**Consultation Response from KC,
Highways Development Management**

2024/90943 217, Barnsley Road, Denby Dale, Huddersfield, HD8 8TS

Erection of agricultural building

Date Responded: 23/07/2024.

PROPOSED AGRICULTURAL BUILDING
HIGHDALE FARM, 217 BARNSLEY ROAD,
DENBY DALE, HUDDERSFIELD HD8 8TS
DWG No. 666-A01 rev--
SCALE 1:500@A3 MARCH 2024

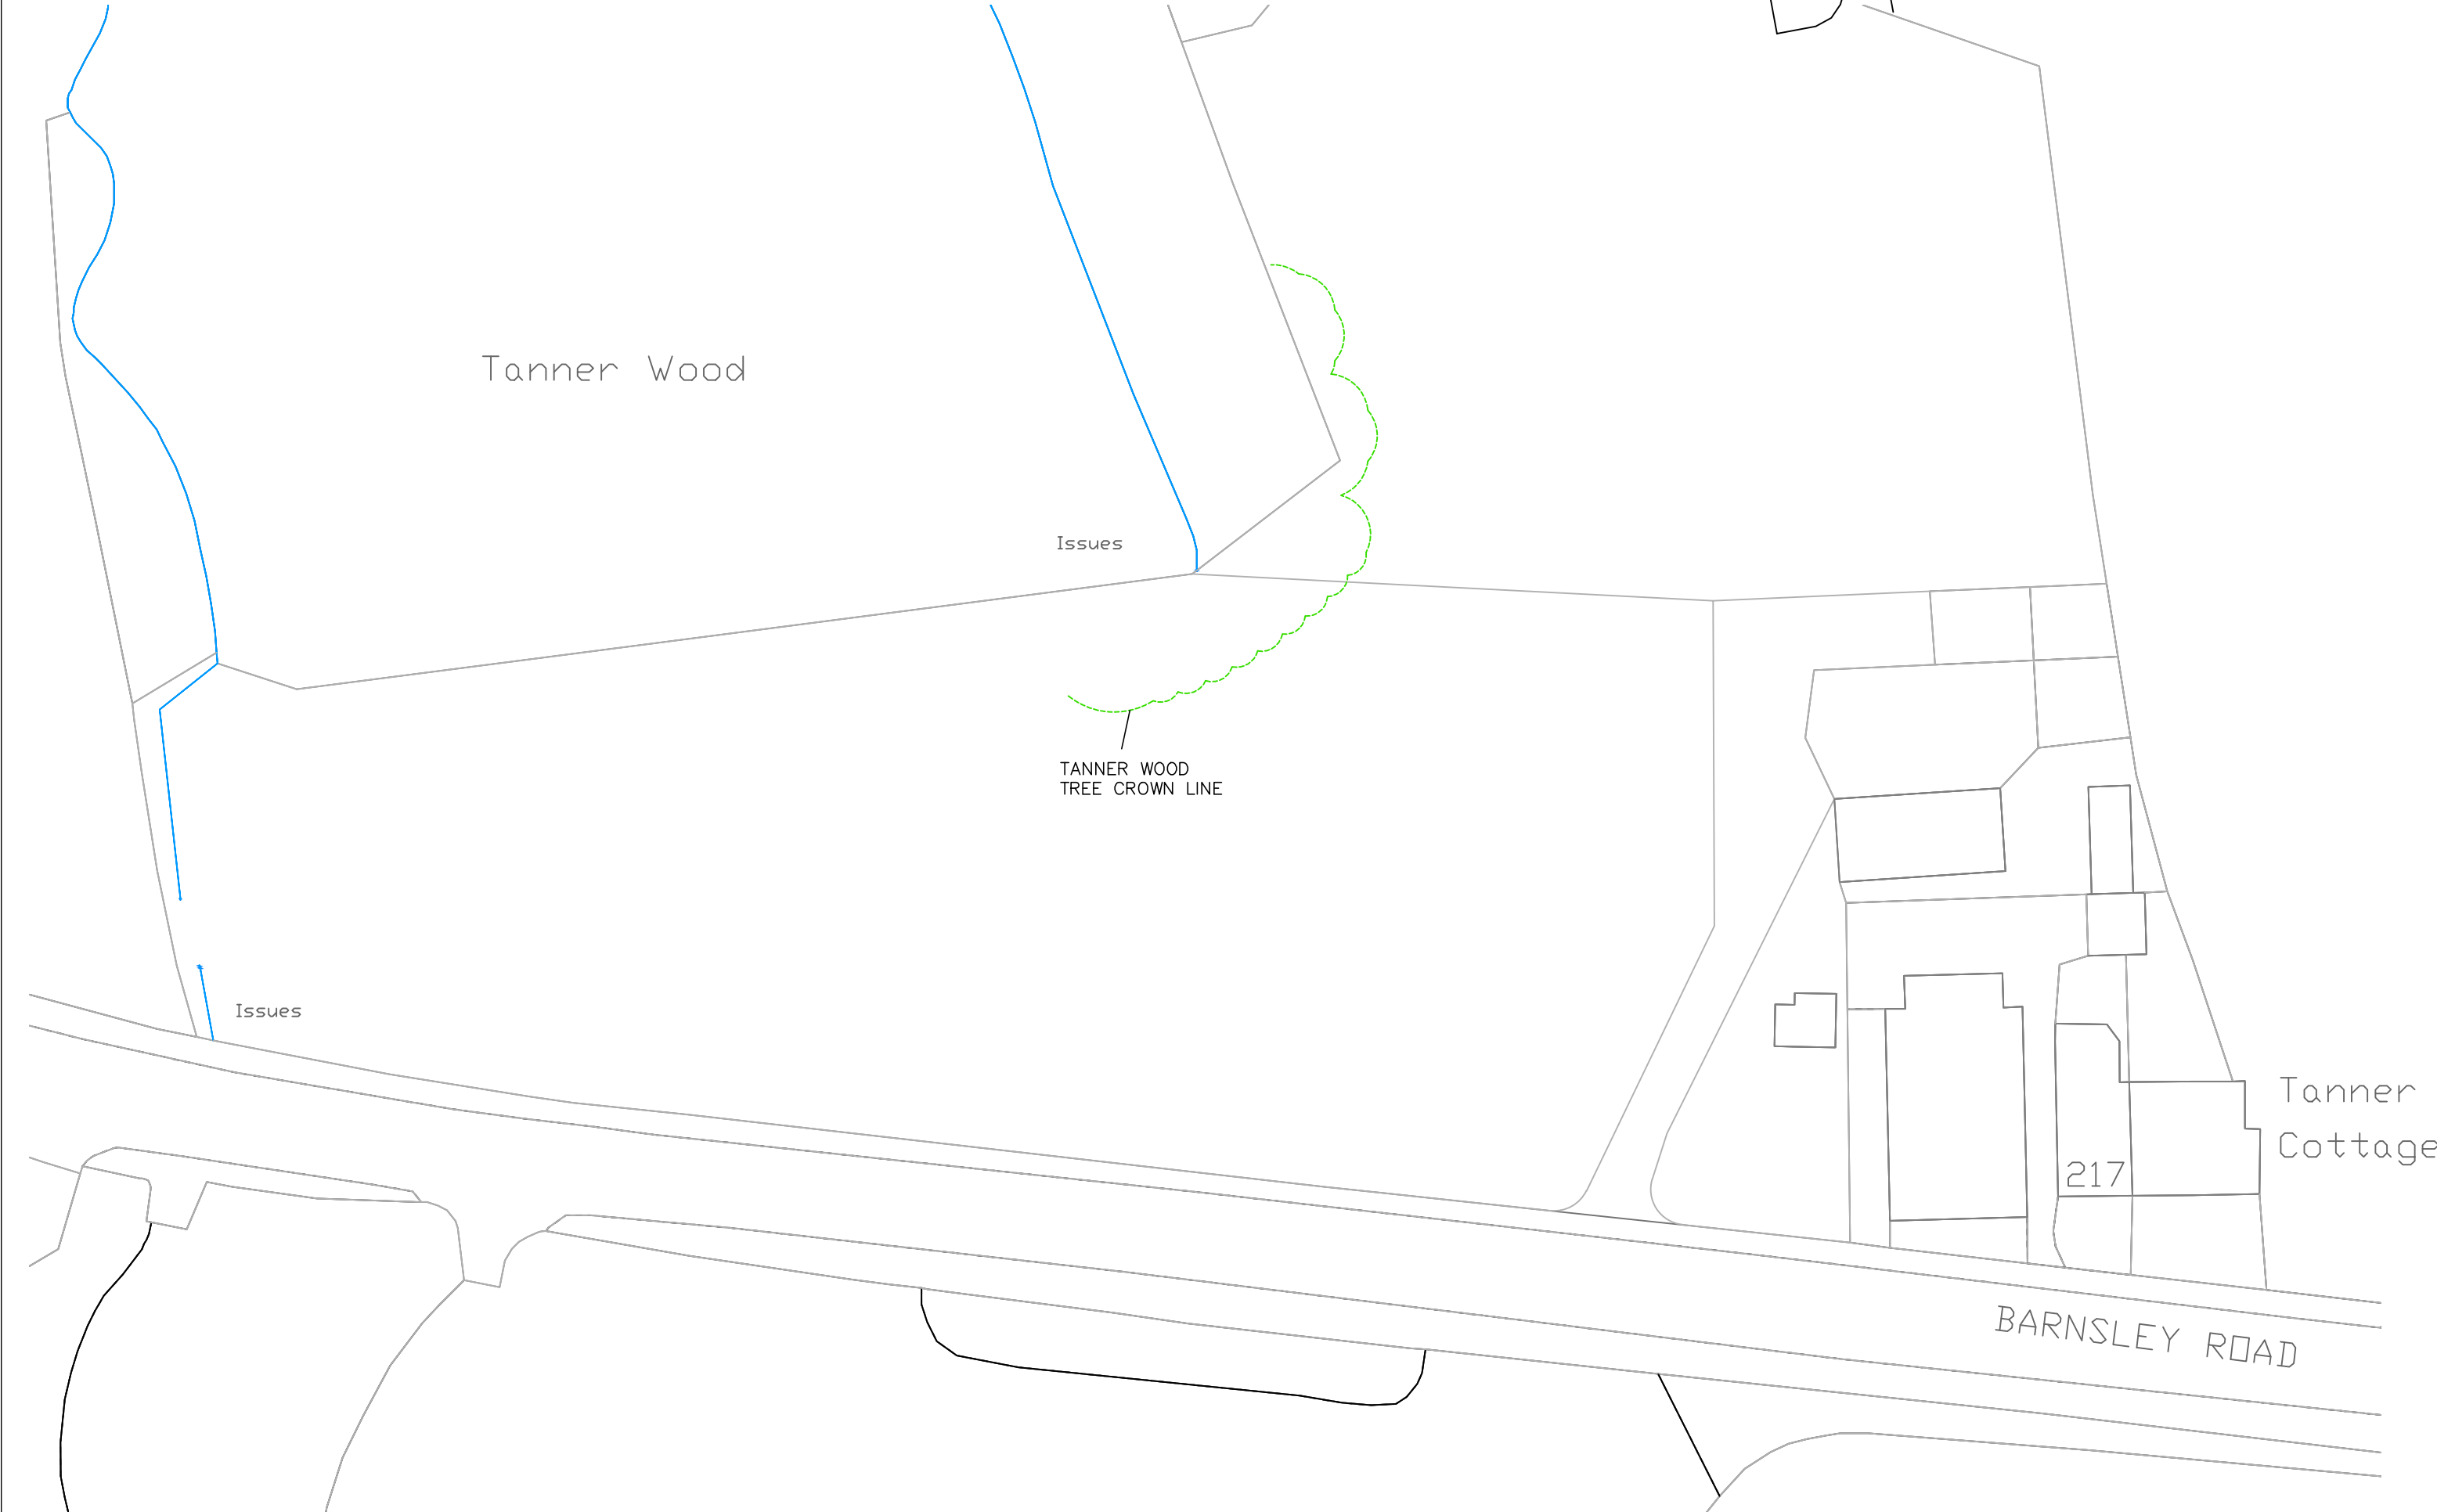
The proposed access uses the existing vehicle access to the site and ample parking is proposed.

Internal turning is available to ensure vehicles can enter and leave the site in forward gear,

This is acceptable in highway terms.

The approved vehicle parking areas will need to be surfaced and drained in accordance with the Communities and Local Government; and Environment Agencies 'Guidance on the permeable surfacing of front gardens (parking areas)' published 13th May 2009 (ISBN 9781409804864) as amended or superseded.
